DECISION DELEGATED TO HEAD OF PLANNING

Application No: H16-0071-25 **Applicant:** Mr B Nowak
Proposal: Extension & alterations to front elevation to porch & storage area
Location: 63 Edinburgh Drive Spalding
Terminal Date: 4th July 2025

<b>Drawing Title:</b>	EXISTING & PROPOSED FRONT ELEVATION LAYOUT
<b>Contractor:</b>	N/A
<b>Architect:</b>	MEADSTONE

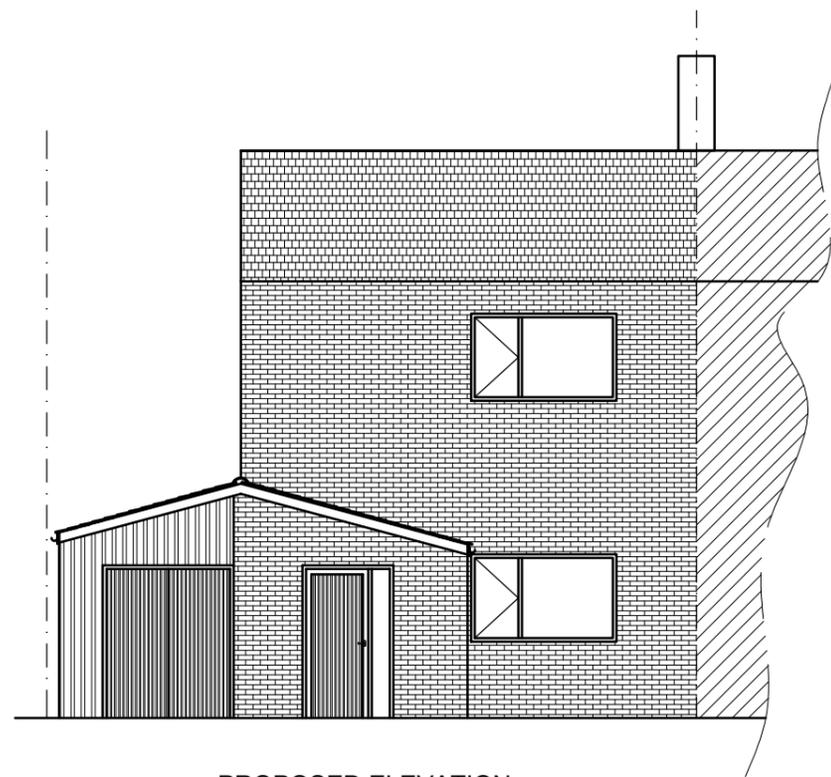
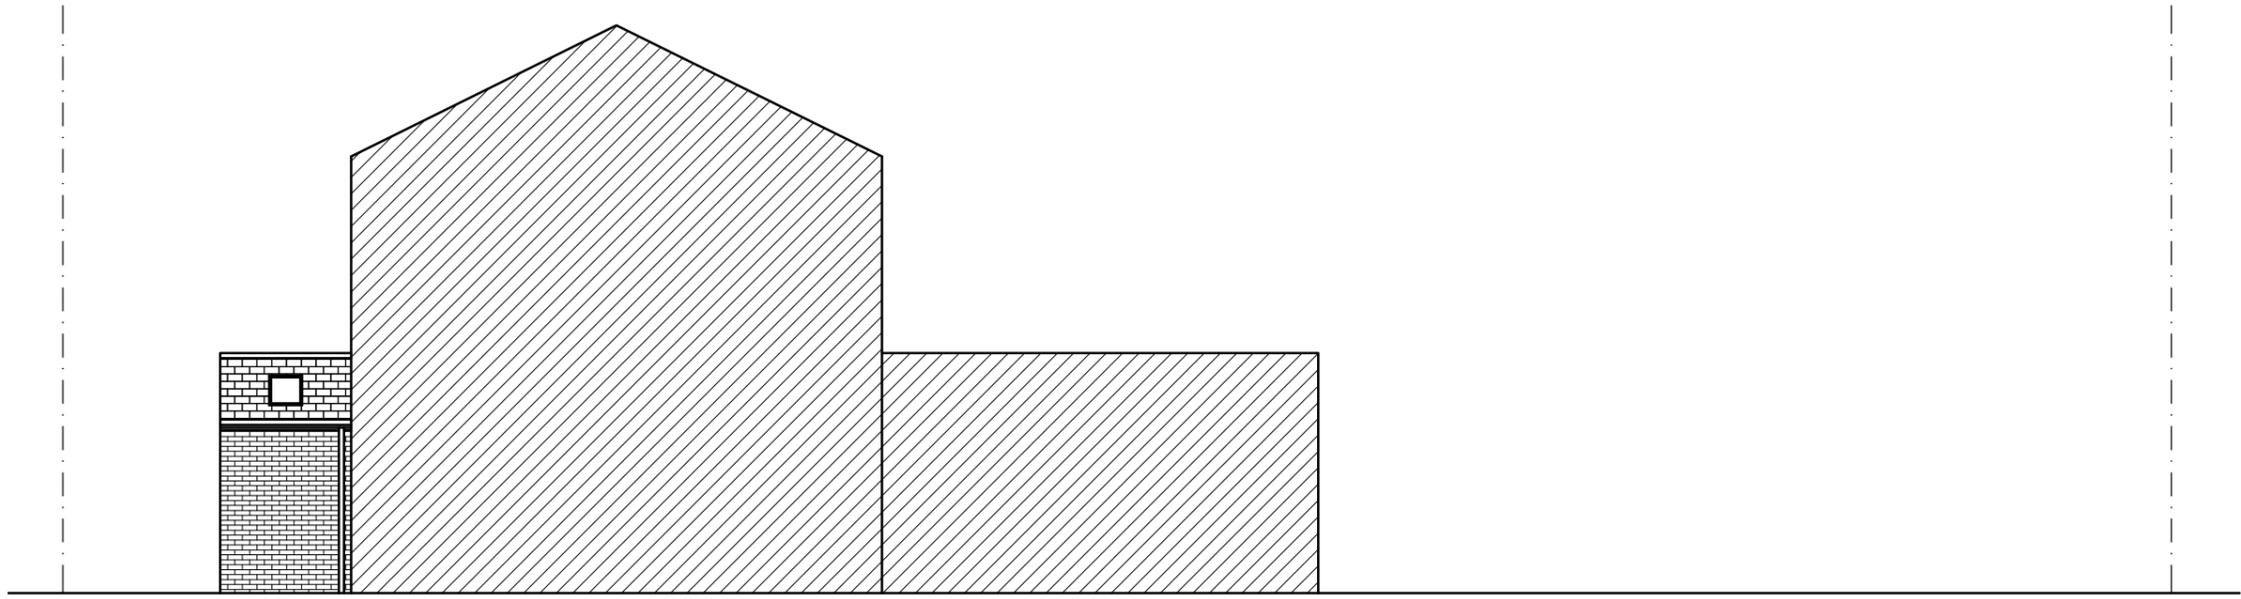
The extension would be constructed from wood clad for the storage and brick for the porch whilst both would be made from tiles for the roof and uPVC for the doors. For the storage section it would protrude from the front by around 3600mm and 1800mm for the porch, they would be connected together making a total width of 5590mm. It would have a total height of 3300mm and a height of 2500mm to the eaves.

Whilst the majority of properties along Edinburgh Drive are of a similar design, the neighbouring property is rendered across all elevations. Alongside this, there is a small side section to No. 63 which is made from wood already, therefore, through extending this and making it out of wood clad it should not harm the street scene or locality. Furthermore, the brickwork should also be in keeping with the host property therefore also remaining in character and should not be incongruous.

Both sections would extend forward of the build line, however the porch on its own is not significantly more than what can be built under permitted development. The height of the porch would be 3.3m whilst the allowance is 3m, this extra 300mm is not considered to be unacceptable or harmful. The limit when measuring the square footage of a porch is 3sqm, the proposal would be just under 6m. Whilst this nearly double, again, the increase is not harmful and should not materially impact the street scene in this instance. Along side this, No. 63 is already different to the other properties in the area due to the side extension, this would be extended forward slightly and would therefore be level with the porch, creating a new build limit only 1800mm forward of the current limit. It is therefore considered that the size and location of the front extension is considered to be suitable and acceptable in this area.

Drawing Title:	PROPOSED PLAN LAYOUT
Contractor:	N/A
Architect:	MEADSTONE

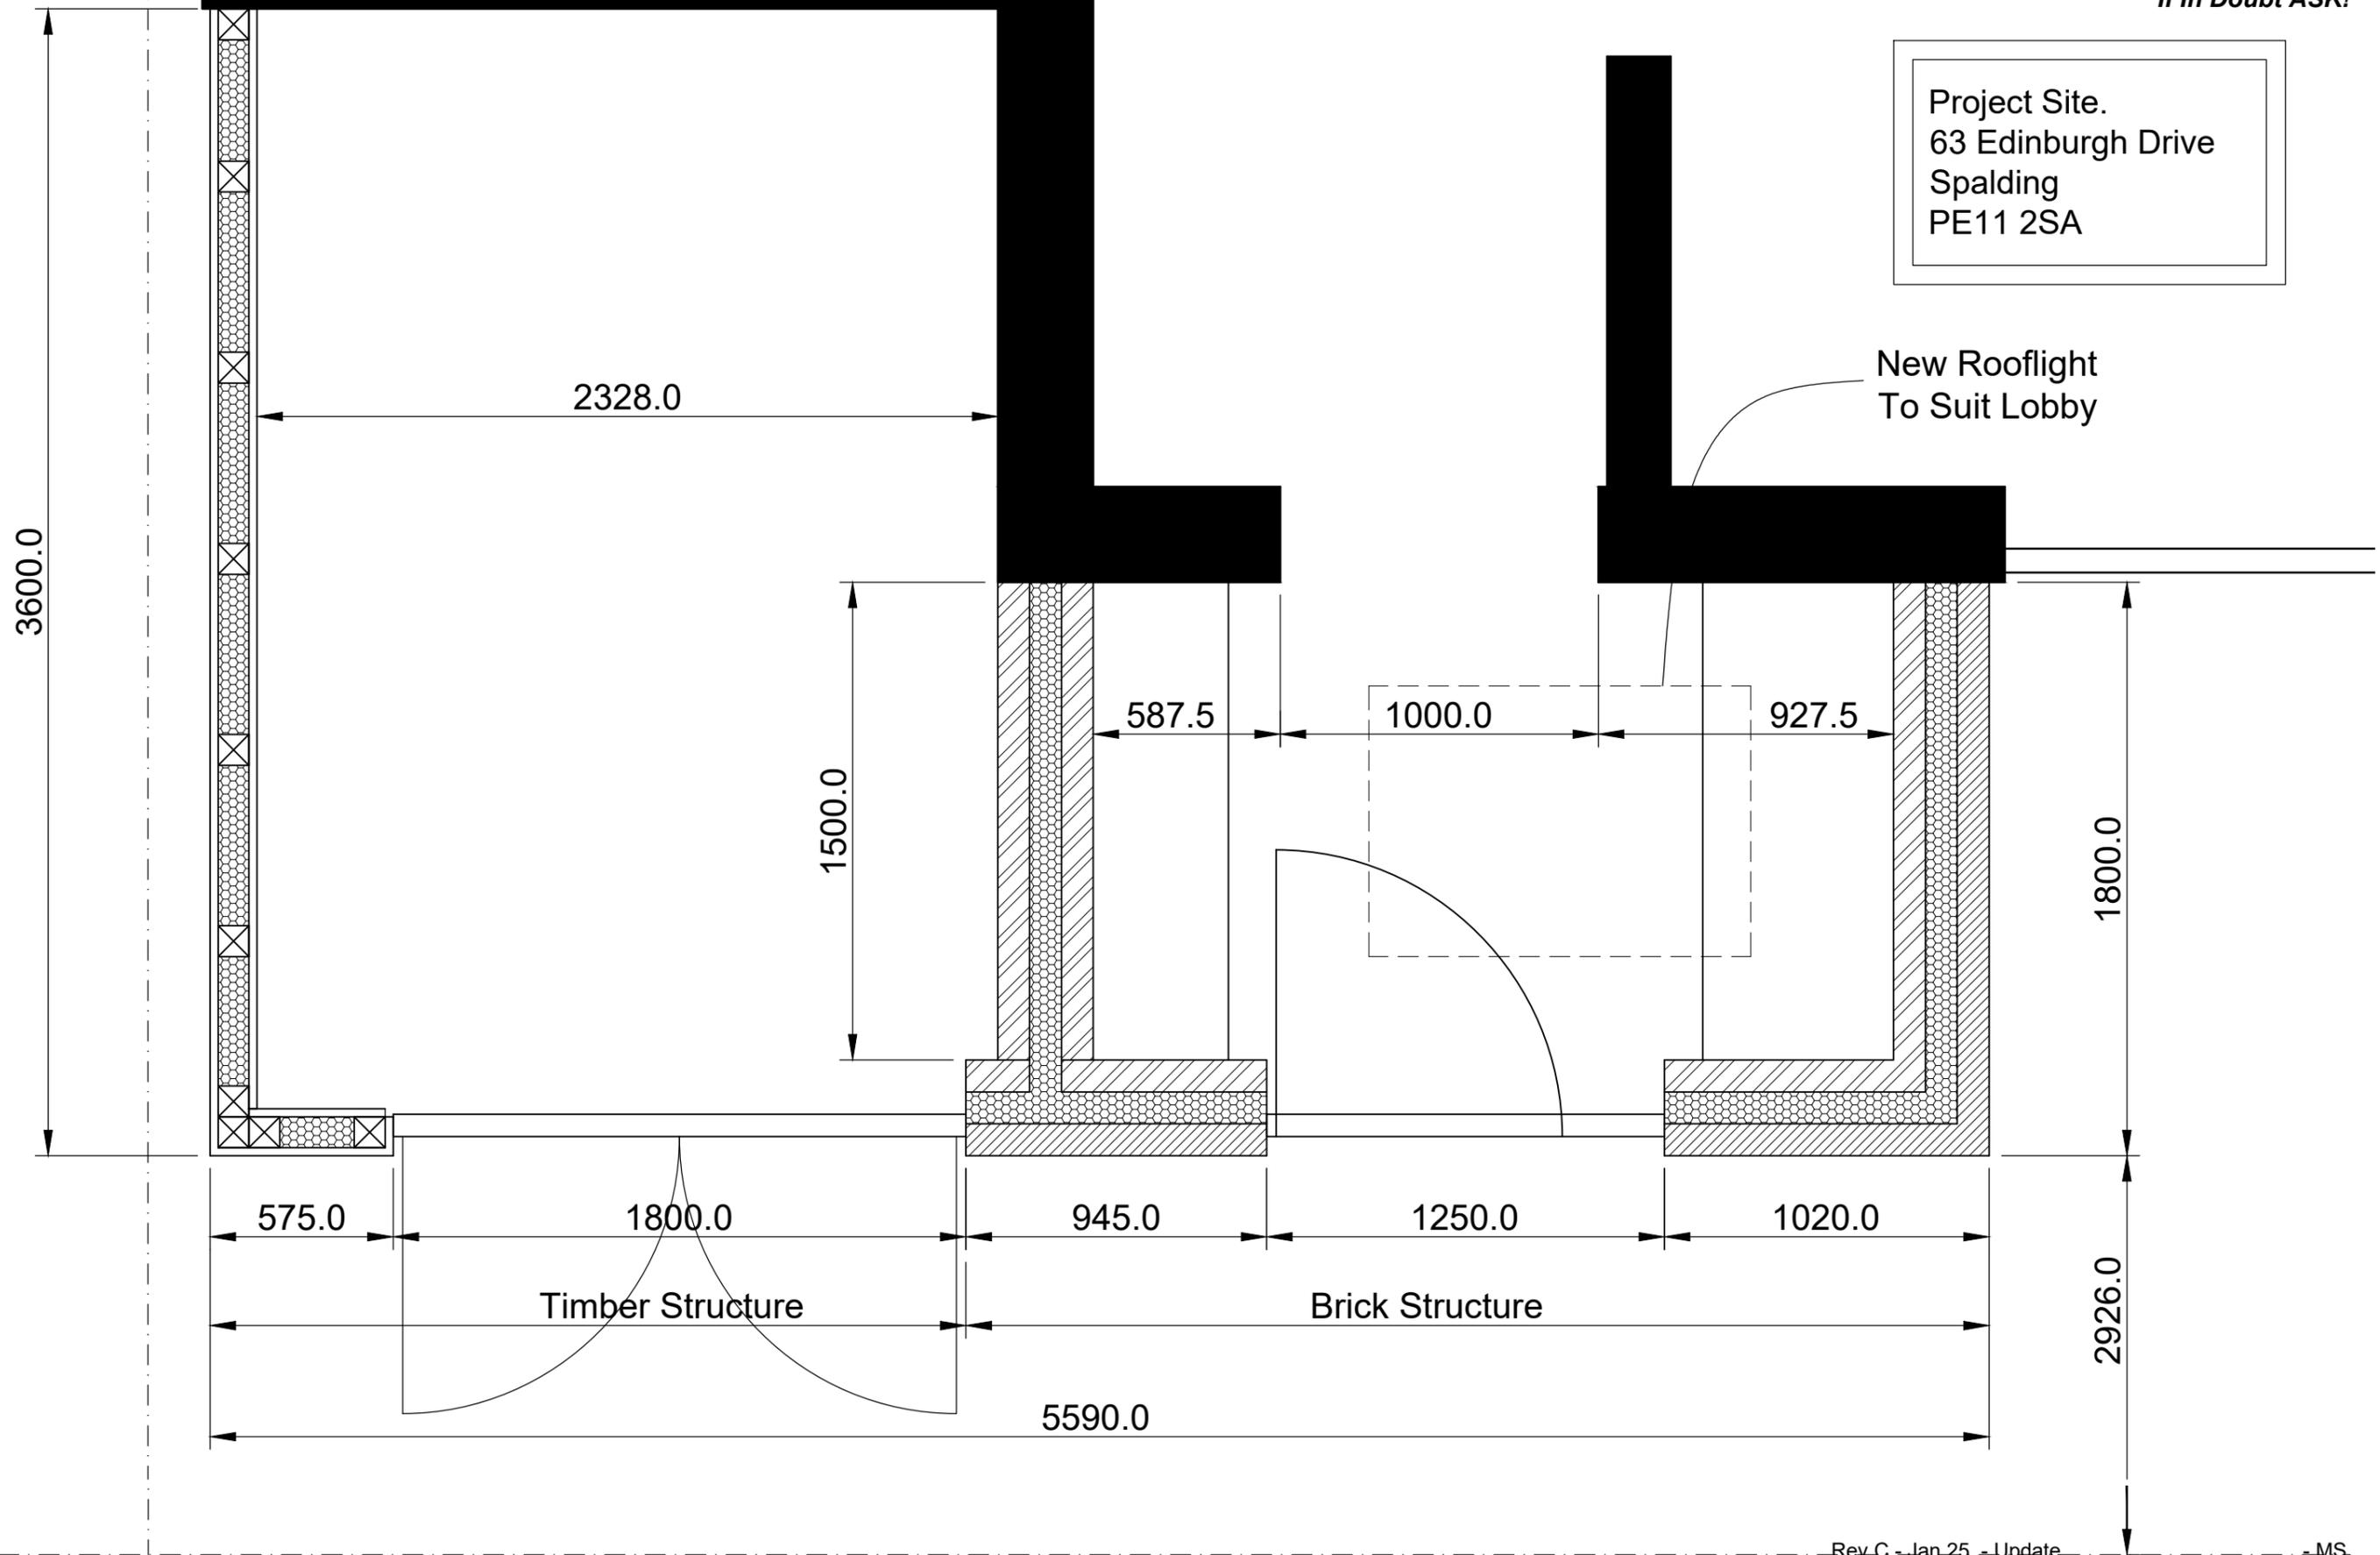
The extension proposes no side or front elevations, whilst there would be a roof light due to the height this would be set at it would ensure that no overlooking opportunities would arise. Furthermore, there would be two new doors to the front however these would not result in any material overlooking in this instance. As the extension would be located mostly to the front and somewhat to the side, this means that any shadow that is cast would be the driveways to the front of the house and not materially impacting any neighbouring windows or amenity spaces.

Drawing Title:	BOUNDARY LAYOUT
Contractor:	N/A
Architect:	MEADSTONE

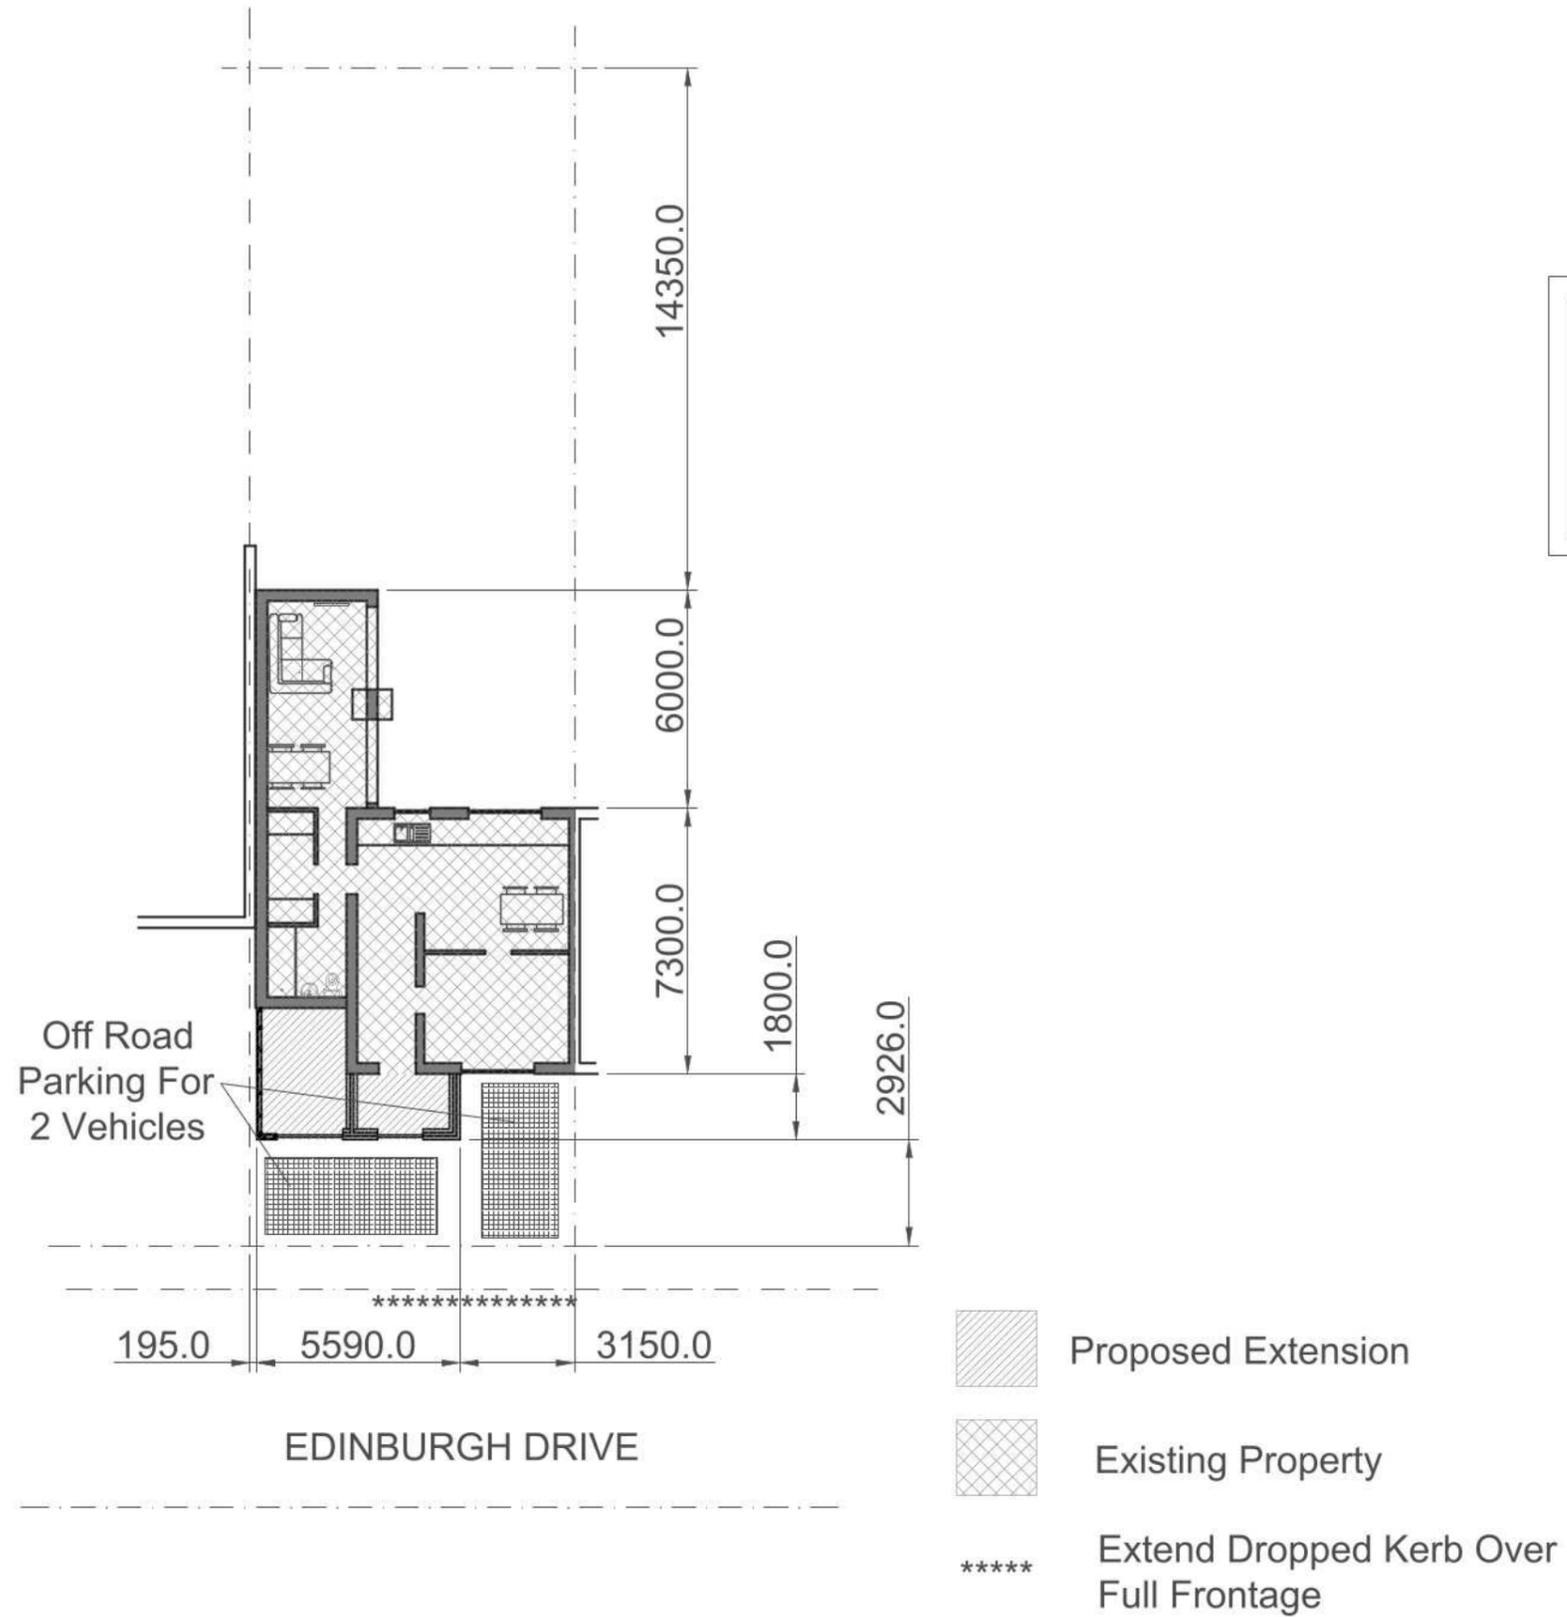
The proposal is for an extension & alterations to front elevation to porch & storage area. Site plan required to detail parking. The proposal will reduce the length of the driveway. The house has three bedrooms. The parking isn't ideal and is narrowly short of the 4.8m for a parking space however it is the same distance shown to be accommodating the car in the google street view just moved to the right side. In order to make it more usable the dropped kerbs will need to be extended over the full frontage - a note has been added to the site plan to say that the vehicle crossing will be extended along the site frontage and will be constructed to Lincolnshire County Council Specification. The proposal will not have an adverse impact on the public highway. As Lead Local Flood Authority, Lincolnshire County

Correspondence with LCC Highways have been ongoing throughout this application with them requesting additional information on multiple occasions, amended plans were submitted to rectify the issues with the final comments stating the following 'The parking isn't ideal and is narrowly short of the 4.8m length for a parking space however it is the same distance shown to be accommodating the car in the google Street view it is just relocated to the right side. To make it more usable the dropped kerbs will need to be extended over the full frontage - a note should be added to the site plan to say that the vehicle crossing will be extended along the site frontage and will be constructed to Lincolnshire County Council Specification'.

A further amendment has since been submitted with LCC Highways now raising no objections to the proposal, their comments can be summarised as follows 'The proposal will reduce the length of the driveway. The house has three bedrooms. The parking isn't ideal and is narrowly short of the 4.8m

for a parking space however it is the same distance shown to be accommodating the car in the google street view just moved to the right side. In order to make it more usable the dropped kerbs will need to be extended over the full frontage - a note has been added to the site plan to say that the vehicle crossing will be extended along the site frontage and will be constructed to Lincolnshire County Council Specification. The proposal will not have an adverse impact on the public highway'. As such, the proposal is considered to be acceptable from a highways point of view.
